Our Case Number: ABP-314724-22

Re: Railway (Metrolink - Estuary to Charlemont via Dublin Airport) Order [2022]
Metrolink. Estuary through Swords, Dublin Airport, Ballymun, Glasnevin and City Centre to Charlemont,
Co. Dublin

**Re: Submission in Relation to Metrolink (Ref: ABP-302010-18)
and Proposed Mater Station**

MATER STATION

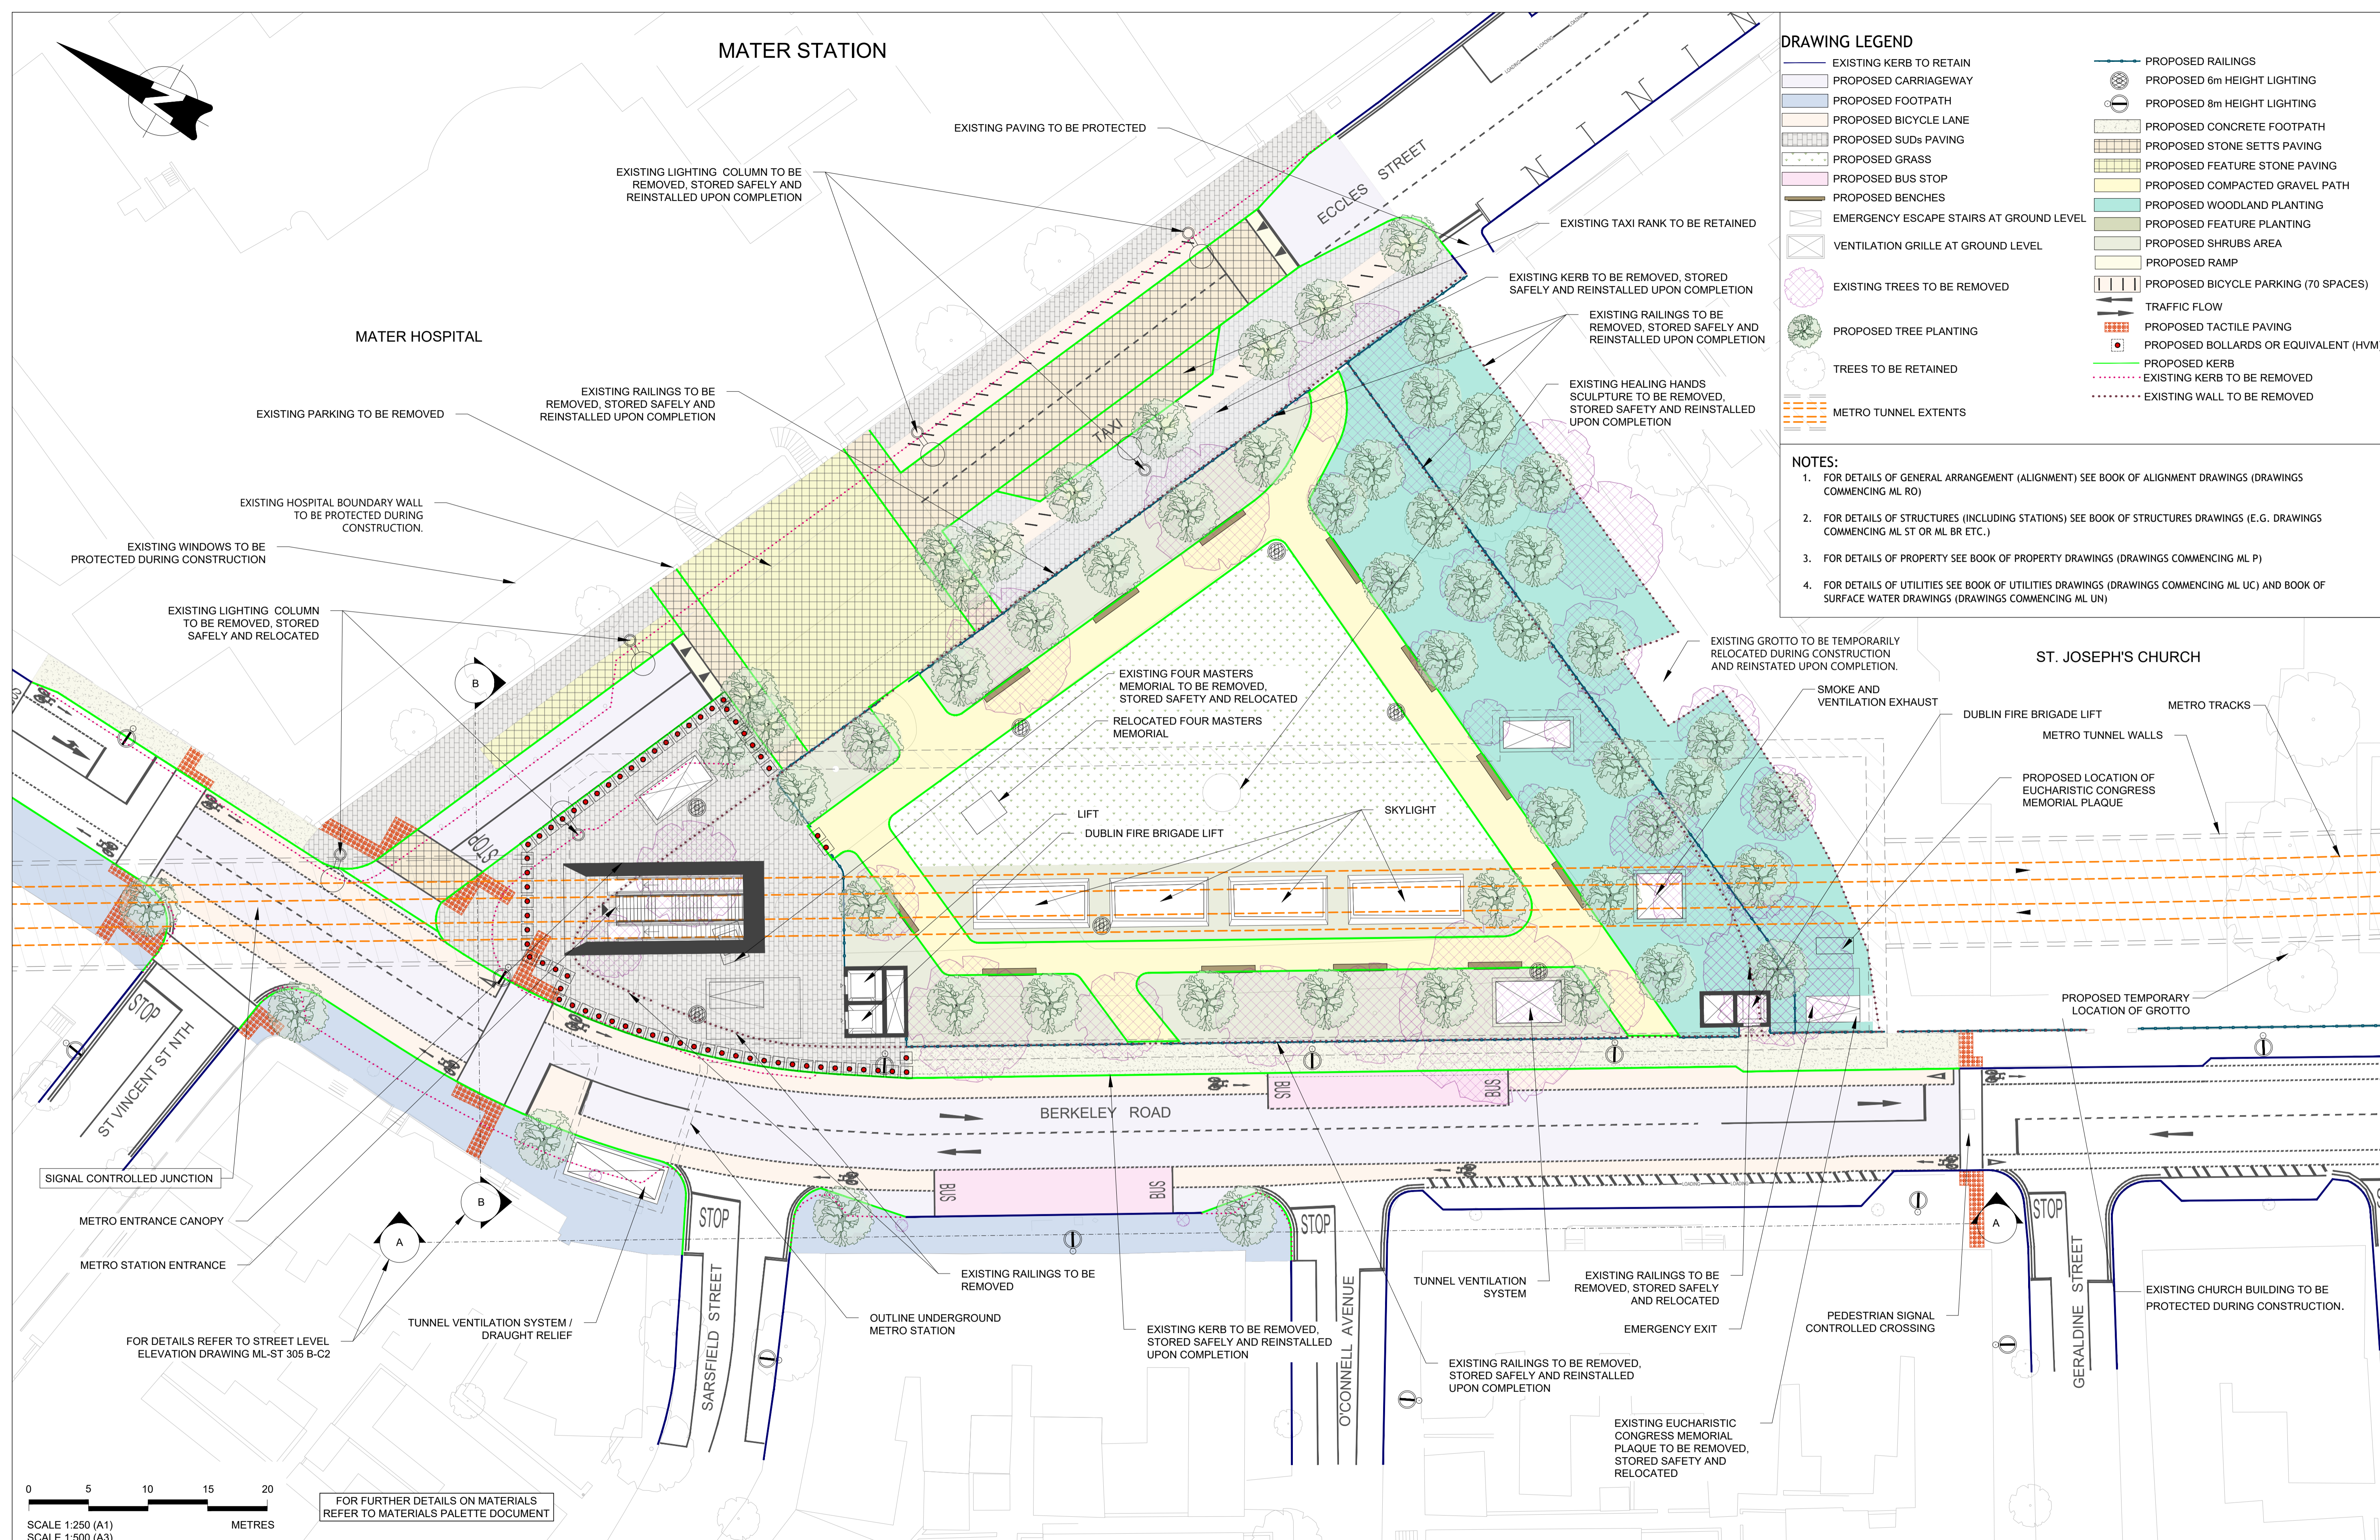
Mater Station is located within an area identified as an 'Architectural Conservation Area' in the current Dublin City Council Development Plan 2016-2022 and the Draft Plan 2022-2028. The Park is zoned Z9: "To preserve, provide and improve recreational amenity and open space and green networks". The railings, gates, some of the statues and plinth walls enclosing the park at the corner of Eccles Street and Berkeley Road, are protected structures which I understand will be stored and reinstated according to the details provided in the Railway Order and accompanying documentation. However, the photomontages illustrating the *ex post* reinstatement of the park show a vastly changed area, with a hard landscaped 'plaza' replacing much of the current soft landscaping, a voluminous (excessively tall and long) station entrance and canopy blocking views of the Mater Hospital from Berkeley Road, and a number of

ancillary buildings which are not in keeping with the architectural surroundings. Such development would be highly deleterious to the visual amenity and architectural heritage of the valuable local streetscape.

- Serious consideration should be given to a reduction in the size of the above-ground Mater Station in both height and length, and/or consideration of an alternative location parallel to St Joseph's Church (on the east of Four Masters' Park) with entrances/exits via Eccles St and Berkeley Rd.

- Ancillary station buildings containing lifts, ventilation shafts, etc., should be redesigned aesthetically, in keeping with the local environment, and with a view to minimising visual intrusion.

- The excessive use of bollards around the station entrance should be avoided, as these detract from the visual amenity and will undoubtedly become damaged. Consideration should be given instead to greener alternatives – such as a row of trees and shrubs – as well as the use of the existing cast-iron railings to form a protective frontage for the station if this is desired.

- All of the historical, protected cast-iron railings and other features of Four Masters' Park should be reinstated.
- Station skylights should be flush with the ground rather than raised, as the current design is visually intrusive.
